TO: Jeff Watson, CDS
FROM: Christina Wollman, Planner III *CW*
DATE: July 13, 2015
SUBJECT: Evergreen Valley BL-12-00030

BL-12-00030

Re: Evergreen Valley (BL-12-00030)

REVISED AREAS

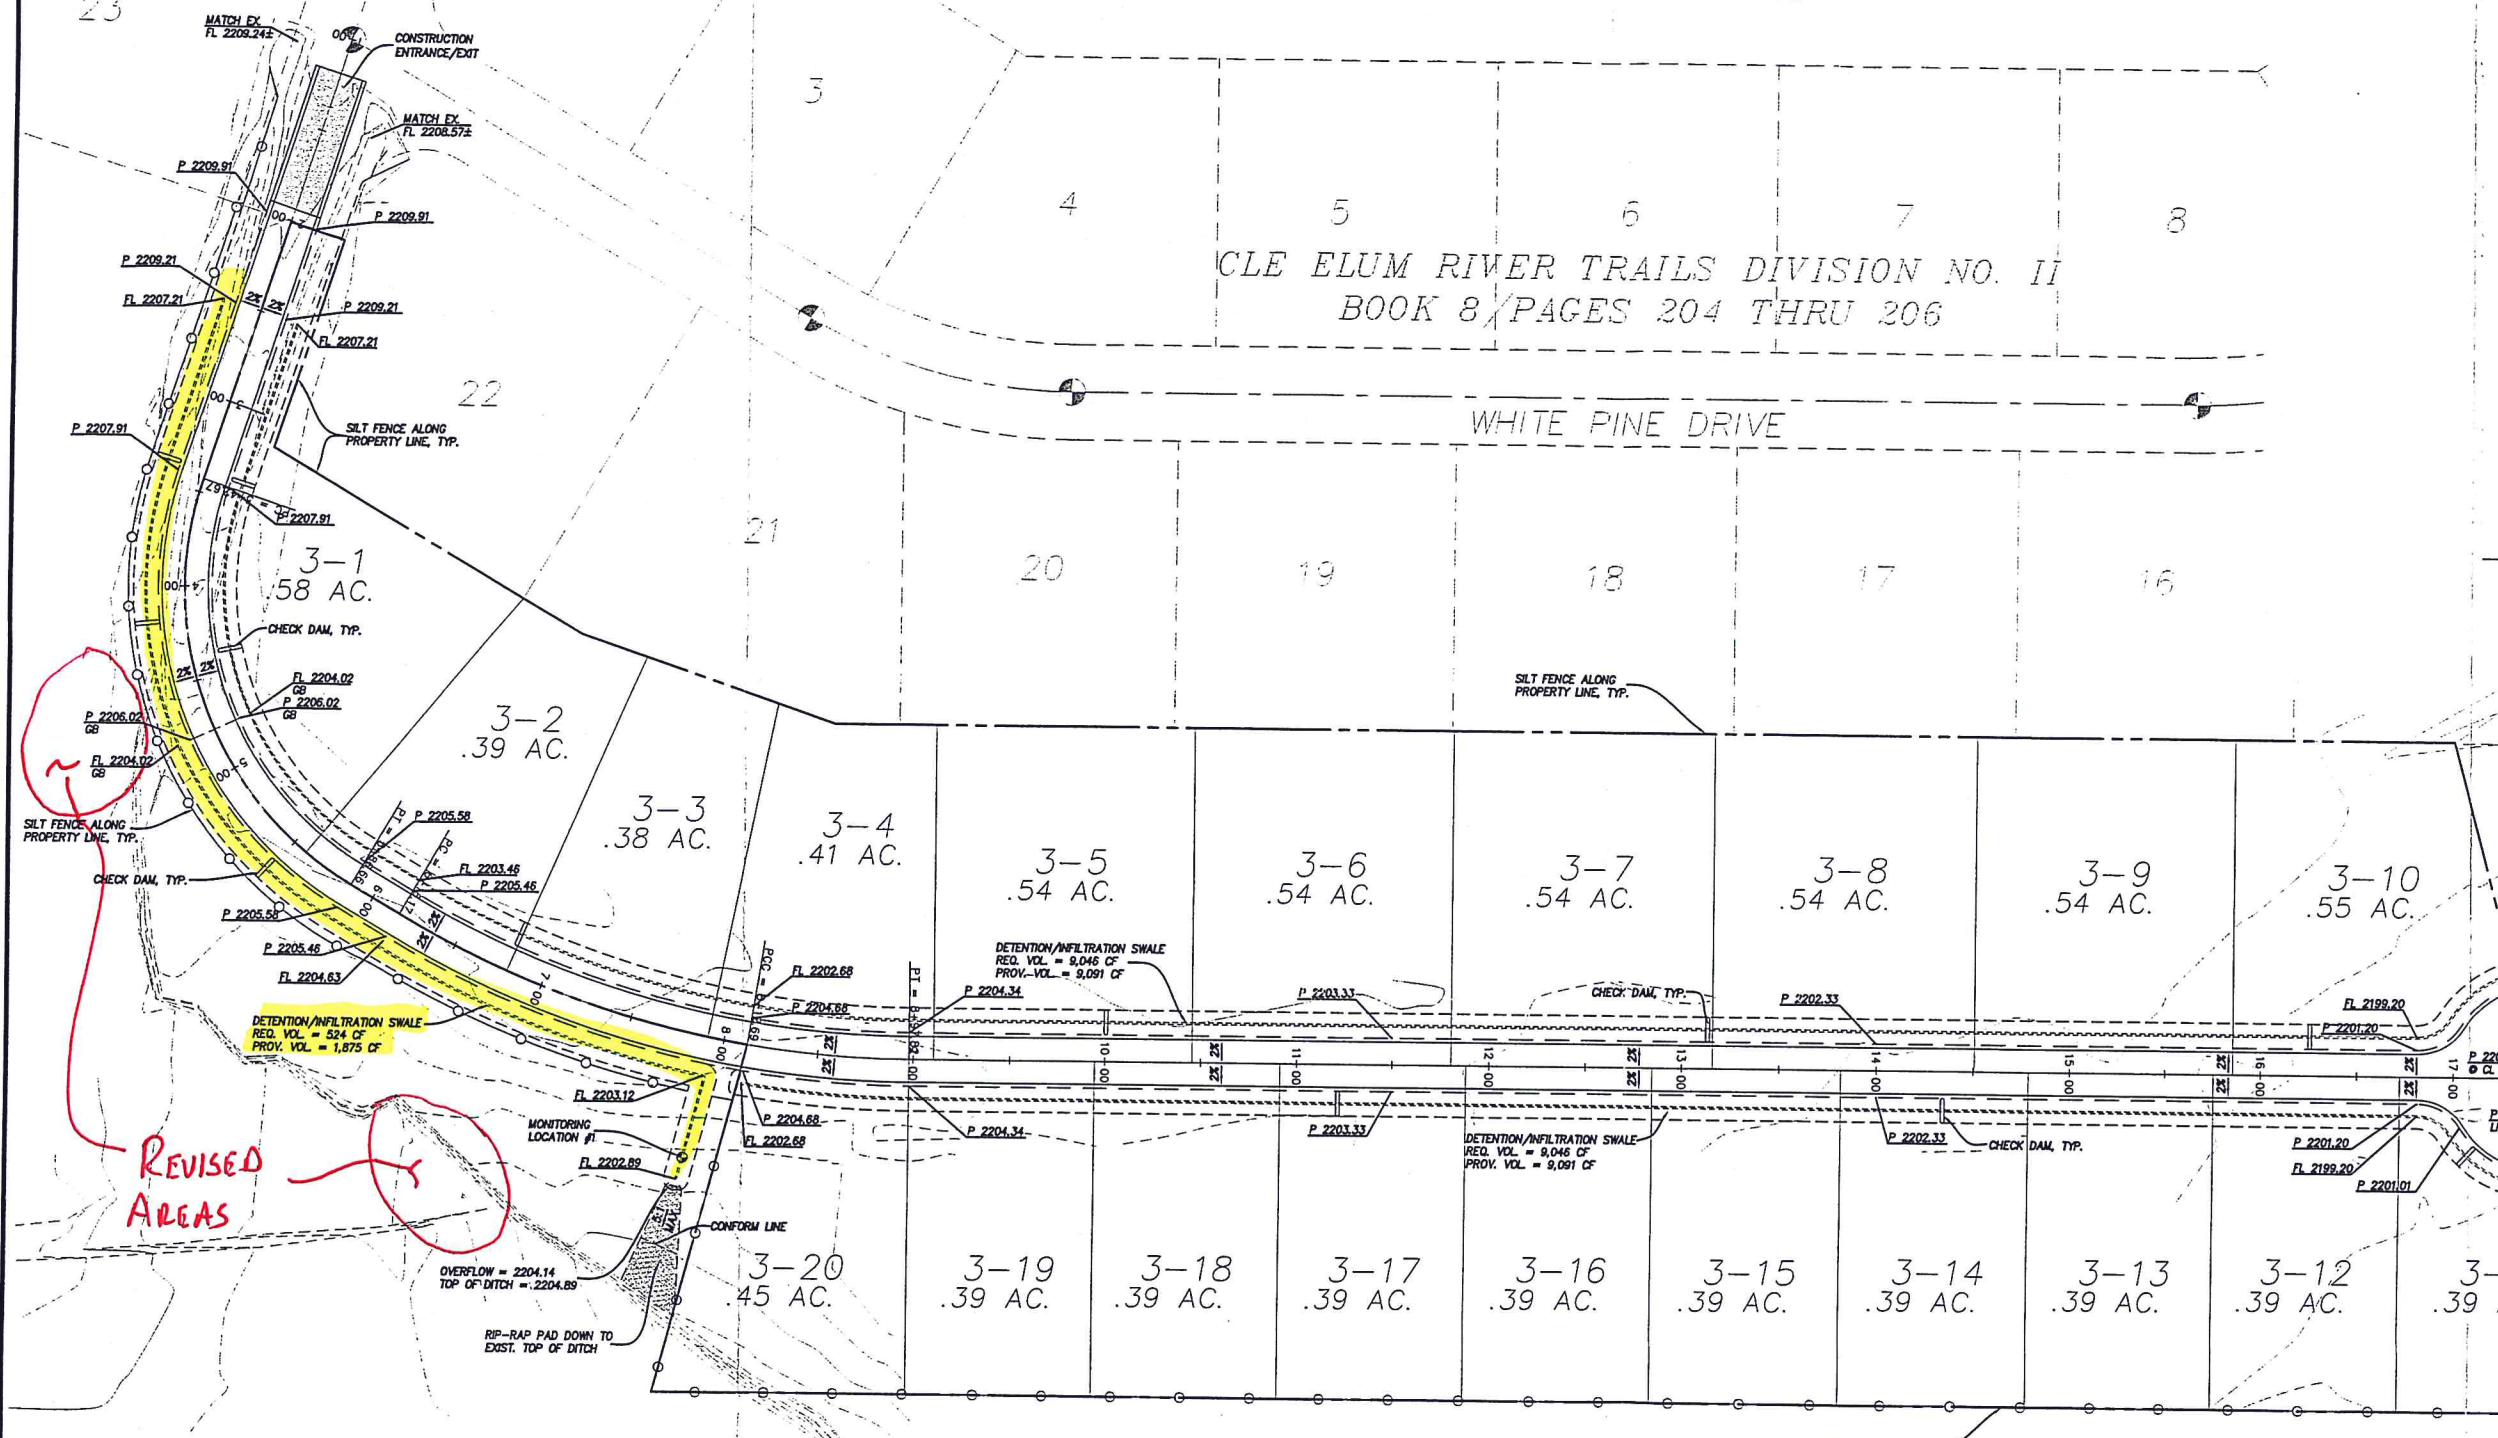
The storm drainage design is largely appropriate. The only additional requirement I have is to construct culverts across all affected properties to assure adequate conveyance of storm water to the retention ponds.
